From: [Borough Planning](#)  
To: "Andy Derrick"  
Subject: RE: Additional information required for 22/00977/F  
Date: 02 August 2022 09:11:54

We have received two location plans (Title plan and Land Registry) with two different red lines, please amend your Location plan and a Block plan. The location plan should be to scale of either 1:1250 or 1:2500 edging the site in question in red and any other adjoining land in applicant's ownership in blue. Unfortunately Block plan to scale of 1:400 is not acceptable, block should be to scale of either 1:200 or 1:500 and show

# Rose Lodge Site/Block Plan

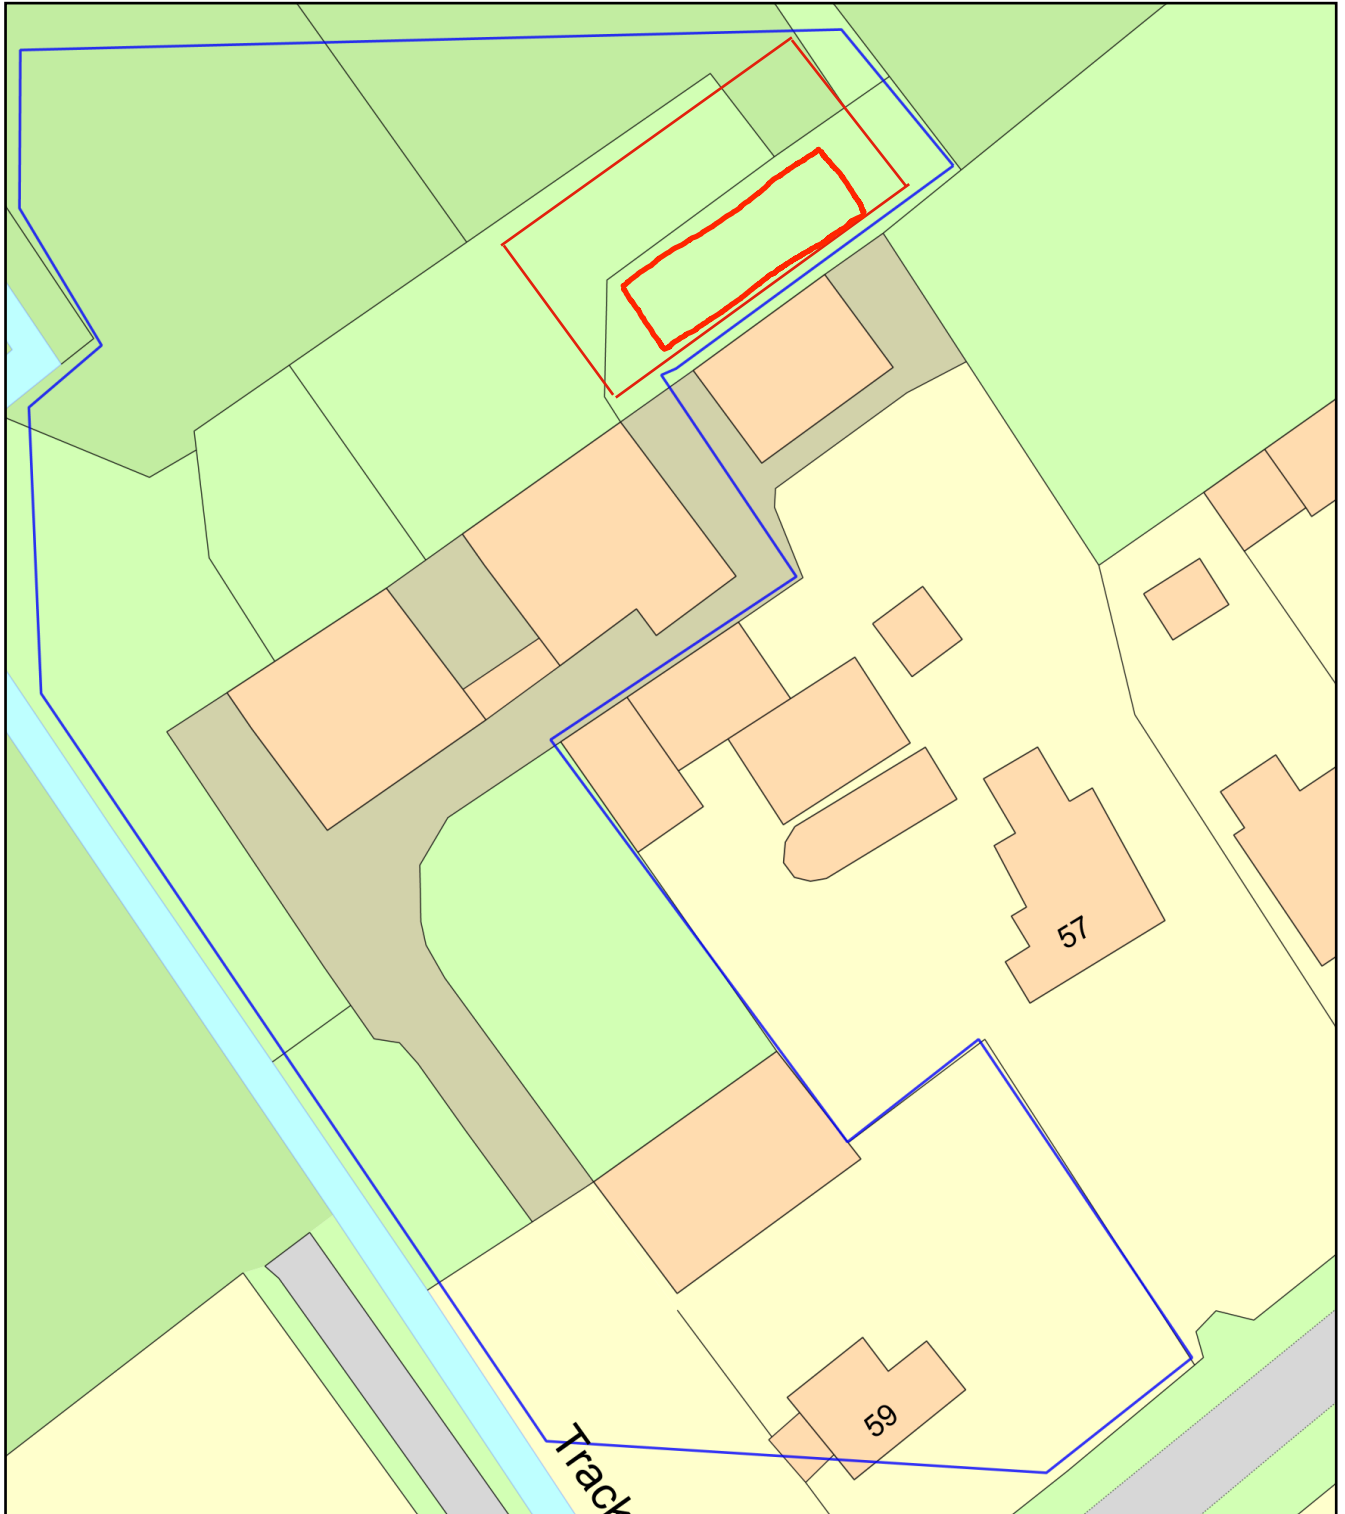
Please find attached example sketch showing what we are looking for, red line outlining the site in question and a blue line edging other land in applicant's ownership. Please note that location plan should show all boundaries of your holding, you can extend your plan to 1:2500 or 1:5000. Similarly, please amend the Block plan

proposed works “from birds eye view” and have red lines around the development site. You can purchase these plans online at [www.planningportal.co.uk](http://www.planningportal.co.uk) - Attached
